From: [Cllr Langford-Smith](#)
To: [Aquind Interconnector](#)
Subject: Submission from Denmead Parish Council before deadline 8
Date: 01 March 2021 10:29:50

Please see below the comments from Denmead Parish Council which we respectfully ask you to consider:

Figure 24.4  
Section 1 - predicted broadband noise levels (pre additional mitigation) from operational converter station (Option B (ii)) and equipment included in noise model.  
Sheet 1 of 1

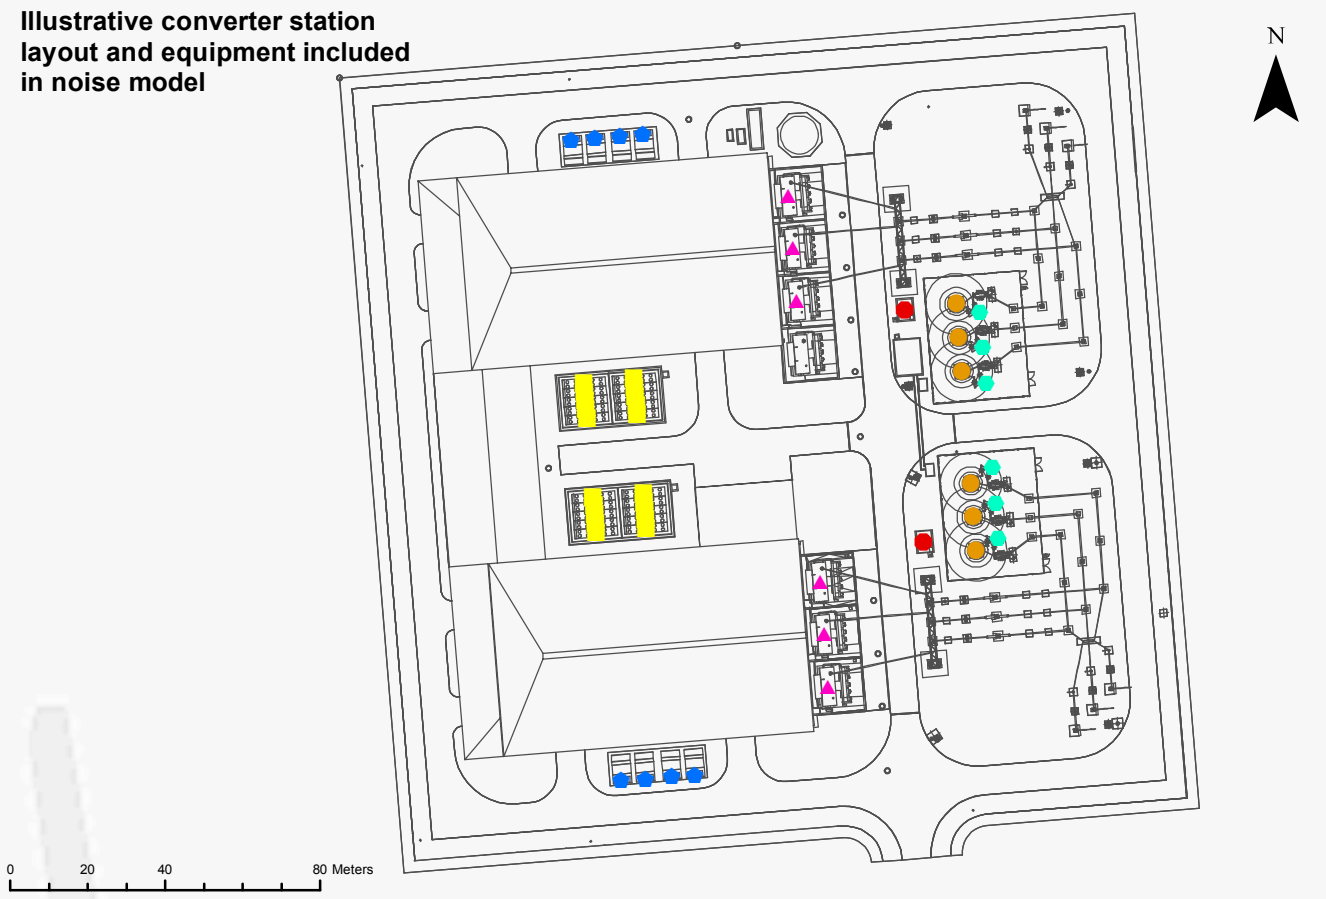
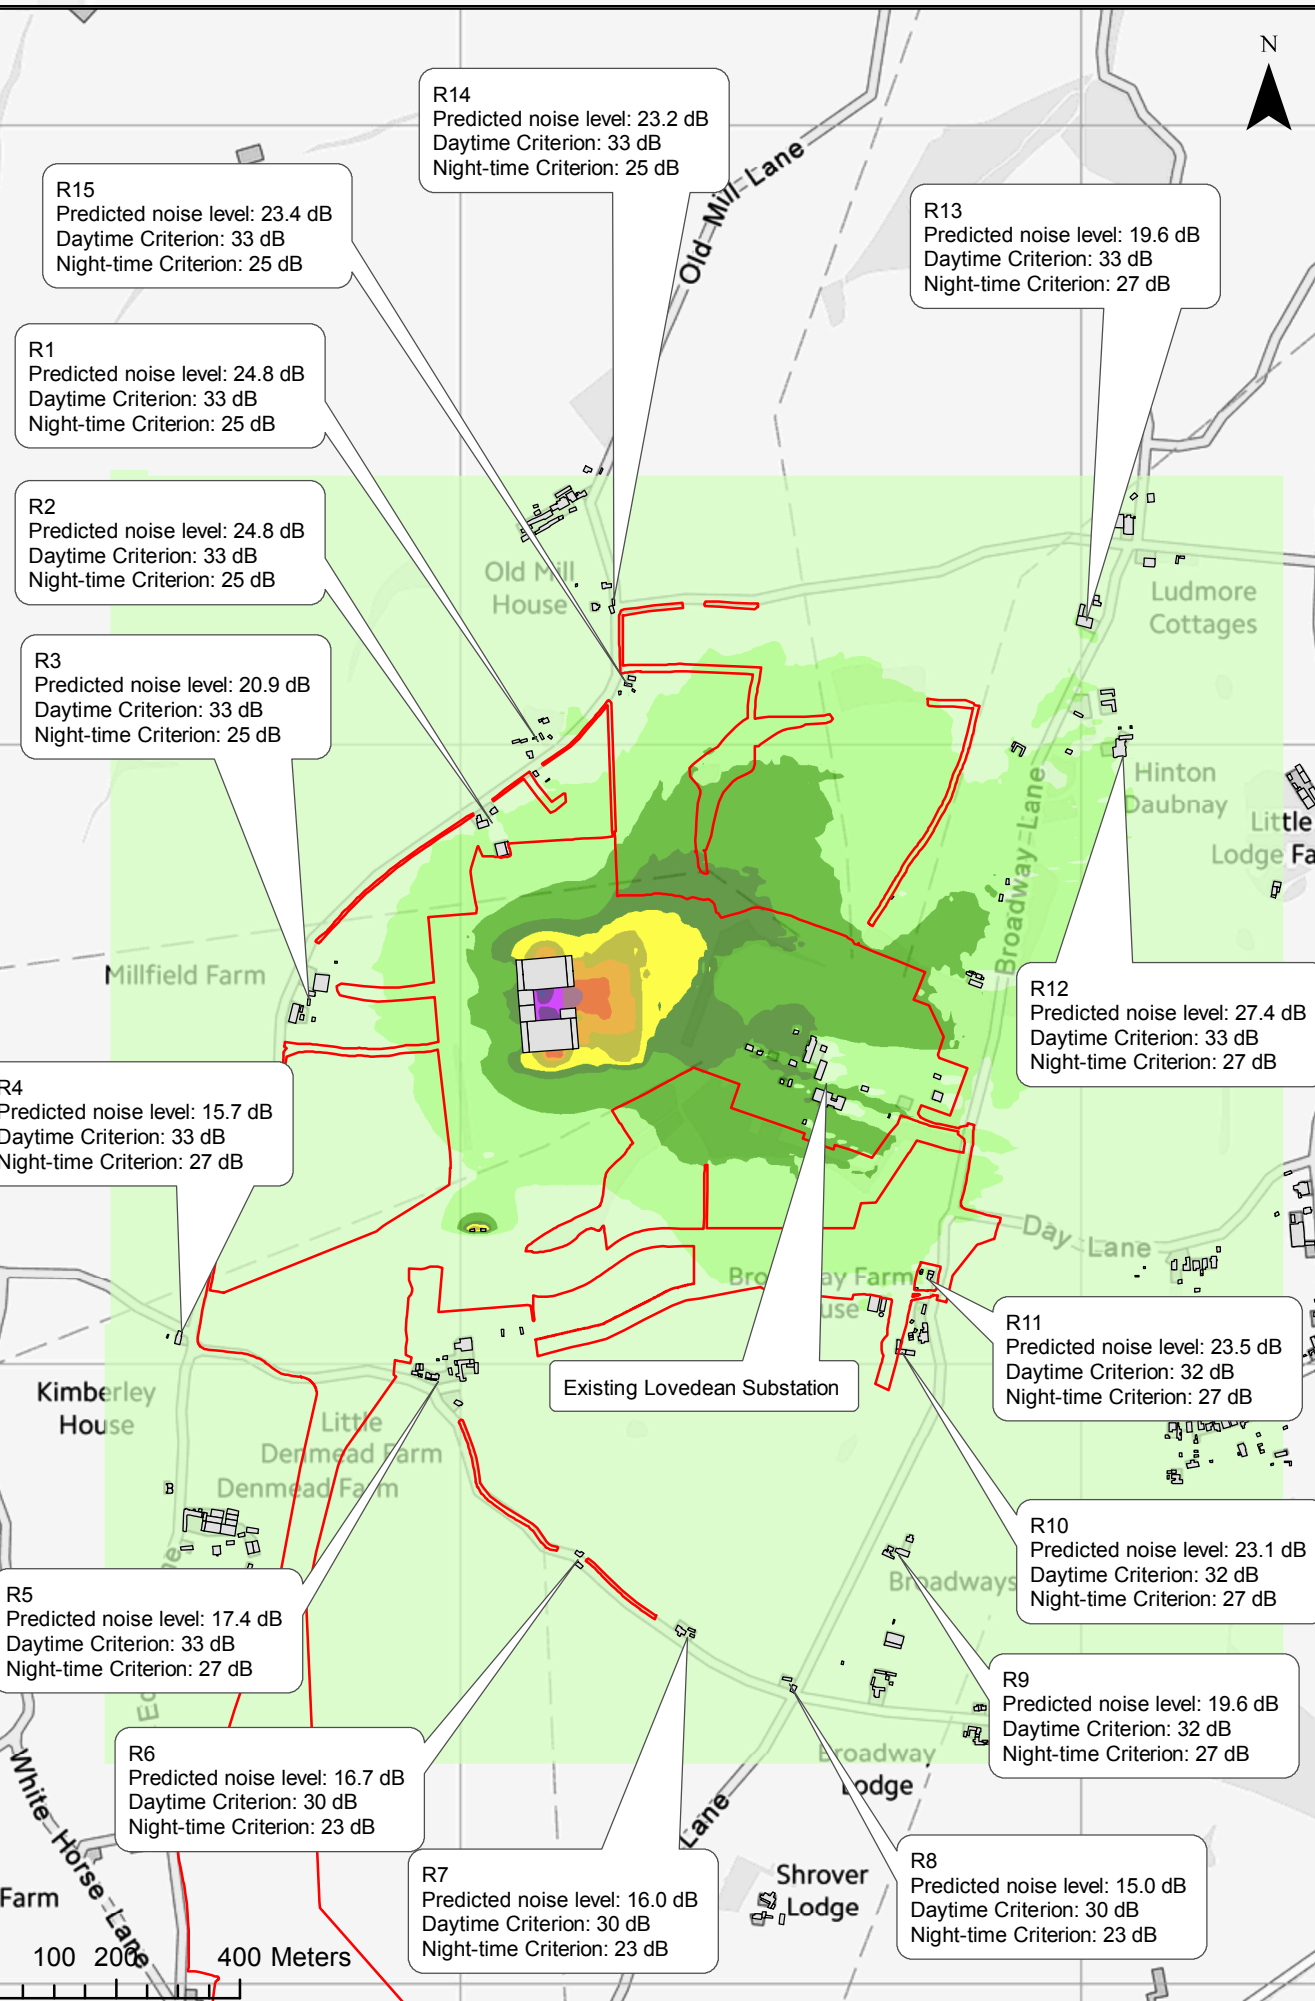
- The micro siting of the converter station which we would prefer option B(ii) where the trees/hedgerow would be retained

The Council has maintained a view throughout the Examination that option B(ii) should be the only scheme to go forward. Now that option B(i) is still under consideration, then the Council feels that it should strengthen that view from severe concern to formally objecting to option B(i) as that option is considered contrary to the intentions of the local planning policies as set out in the consideration of this issue in section 4.6.9 of the Council's Local Impact Report (REP1-183). The planning policy context, commentary and conclusion from that section are copied below:

If micro siting option B(ii) is adopted all the above negative aspects would be removed with only the east west hedgerow HR07 being removed.

The Council favours option (B(ii) as having the least impacts on natural features and habitat. Given the magnitude of the impacts associated with the implementation of option B(i) the Council would have severe concerns based on the landscape and biodiversity impacts as set out above. It is hoped the negotiations with the Grid can be successfully concluded.
